From: Bernadette Owens
Sent: 07 September 2021 12:49
To: DC Support
Subject: FW: Planning notification for application reference: 21/02467/F

I am commenting on the above application from an arboricultural aspect.

Proposal – to build a hotel, offices and other facilities with landscaping

03 Extra Heavy Standard Tree in Soft Landscape
Scale 1:20

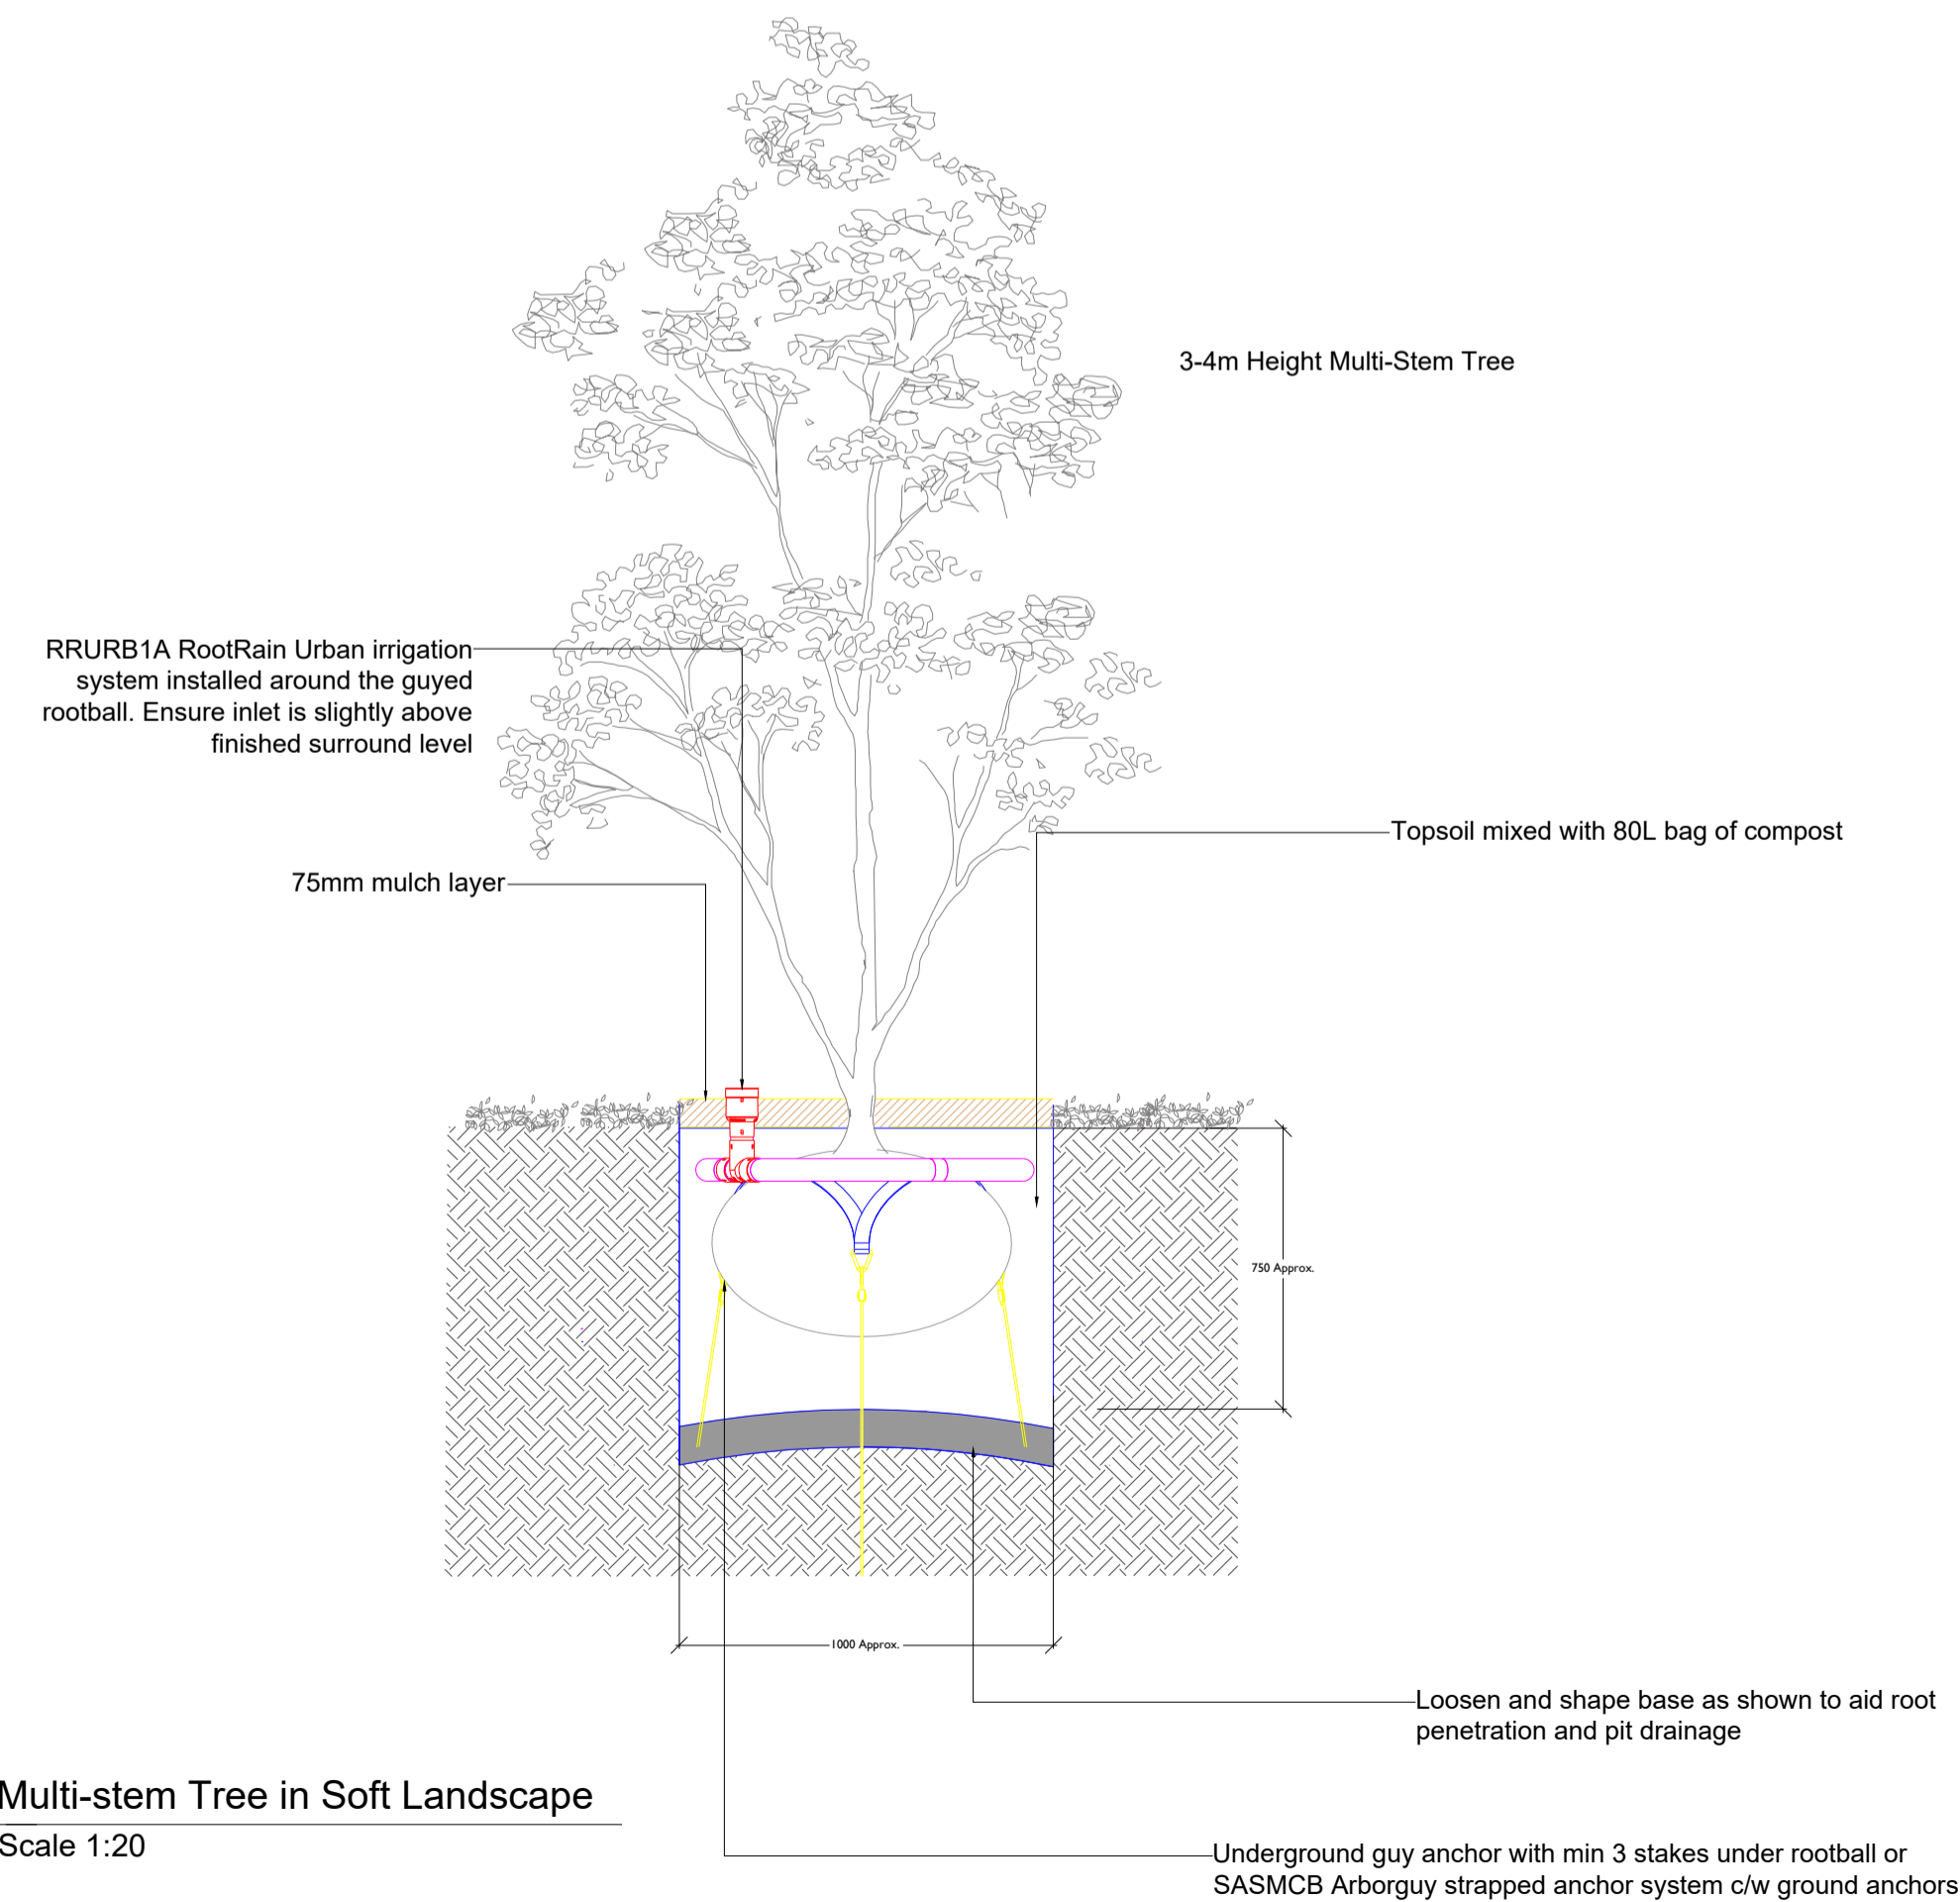
1. The submitted arboricultural report and method statement does not relate to this proposed layout so an updated report is required.
2. The landscape detail plan does not have a tree pit design.
3. The maintenance schedule requires more detail and cover a 2 year period to establishment.
4. All the trees should be 12-14 cm size to ensure a more established landscape.
